**Consultation Response from KC,
Lead Local Flood Authority**

2023/91032 12, Highroyd, Lepton, Huddersfield, HD8 0EB

Demolition of existing conservatory and erection of single and two storey side and rear extension

- Drawing Ref: 0110/2017-05, Proposed Plans and Elevations, Rev B dated Mar 23

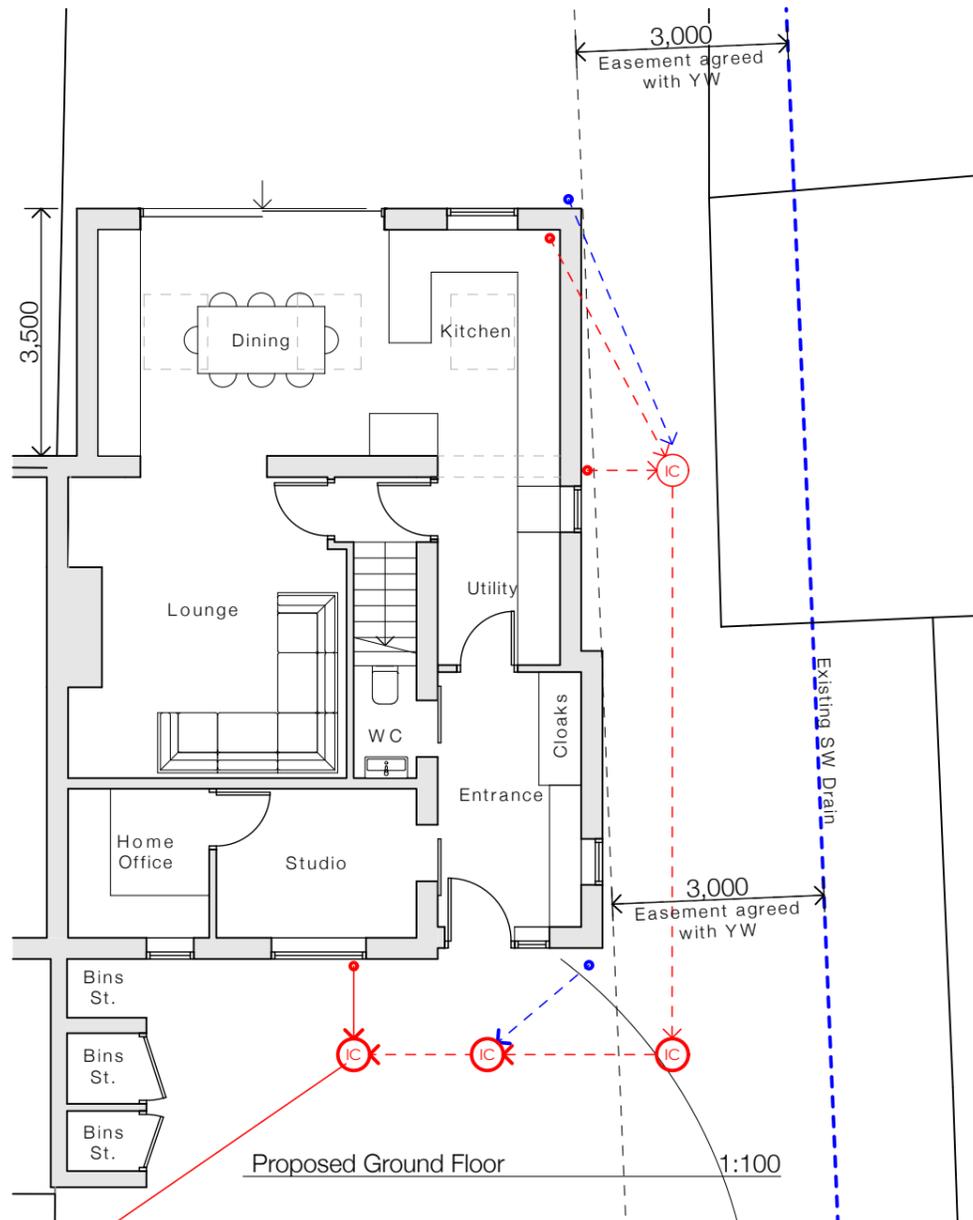
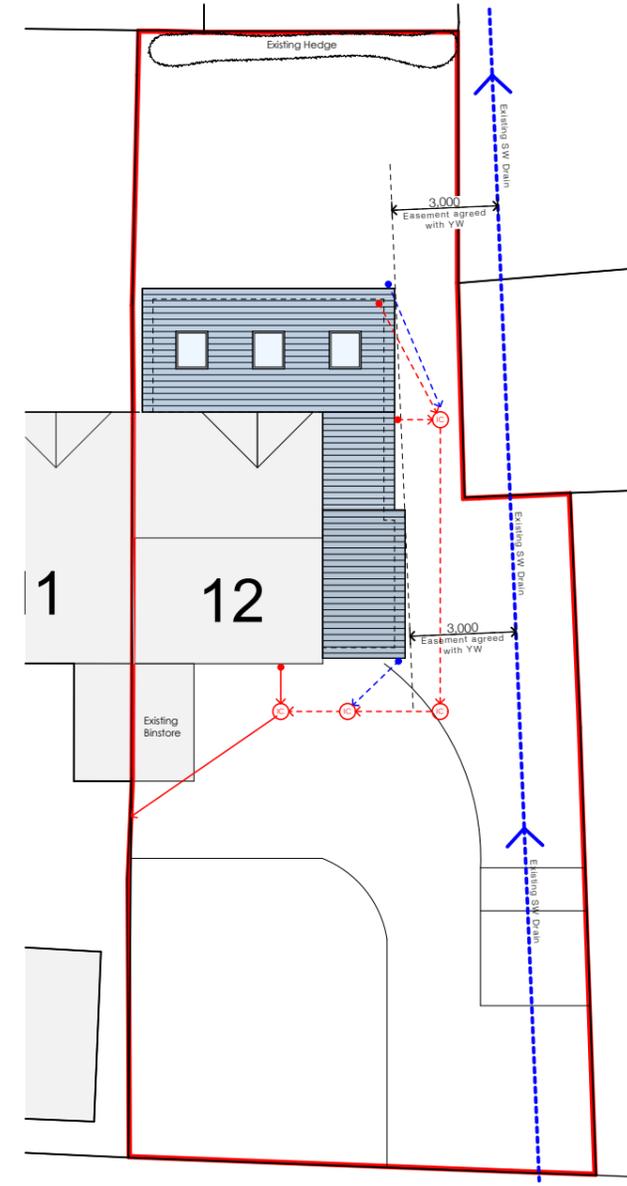
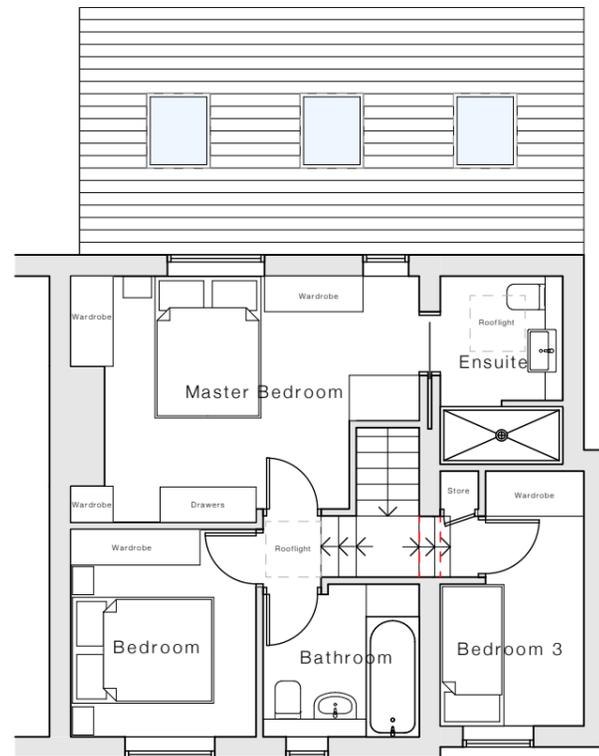
Kirklees Council records indicate that the centreline of the existing 450mm diameter culvert is 4.45m from the building's existing side wall. The culvert drains an area of 3.2 ha south of Wakefield Road and discharges surface water into a YW sewer in Highgate Lane. It appears that the location of the culvert shown on the site plan has only been determined from asset record plans which are often inaccurate.

It is noted that Yorkshire Water has confirmed that a 3.0m easement is required between the culvert and the new build and that this is the same as the Council's Flood Risk Management Department requirement for a minimum easement (measured from any new foundations to the centre of the culvert).

The developer is required to confirm the **depth, condition, and exact position** of the existing culvert adjacent to the new extension. A CCTV survey of this length of culvert will be required to confirm the condition of the culvert and any defects notified to the Council. It is suggested that the developer discusses these requirements with the LLFA.

Note that if it is found that any new foundations will be within the easement, then these foundations will be required to extend in depth down to the invert level of the culvert. Note further that an absolute minimum easement of 2.0m will be required in this instance.

Kirklees Flood Management and Drainage, as the Lead Local Flood Authority (LLFA), OBJECTS to this application until further information on position, depth, and condition of the existing culvert is provided.
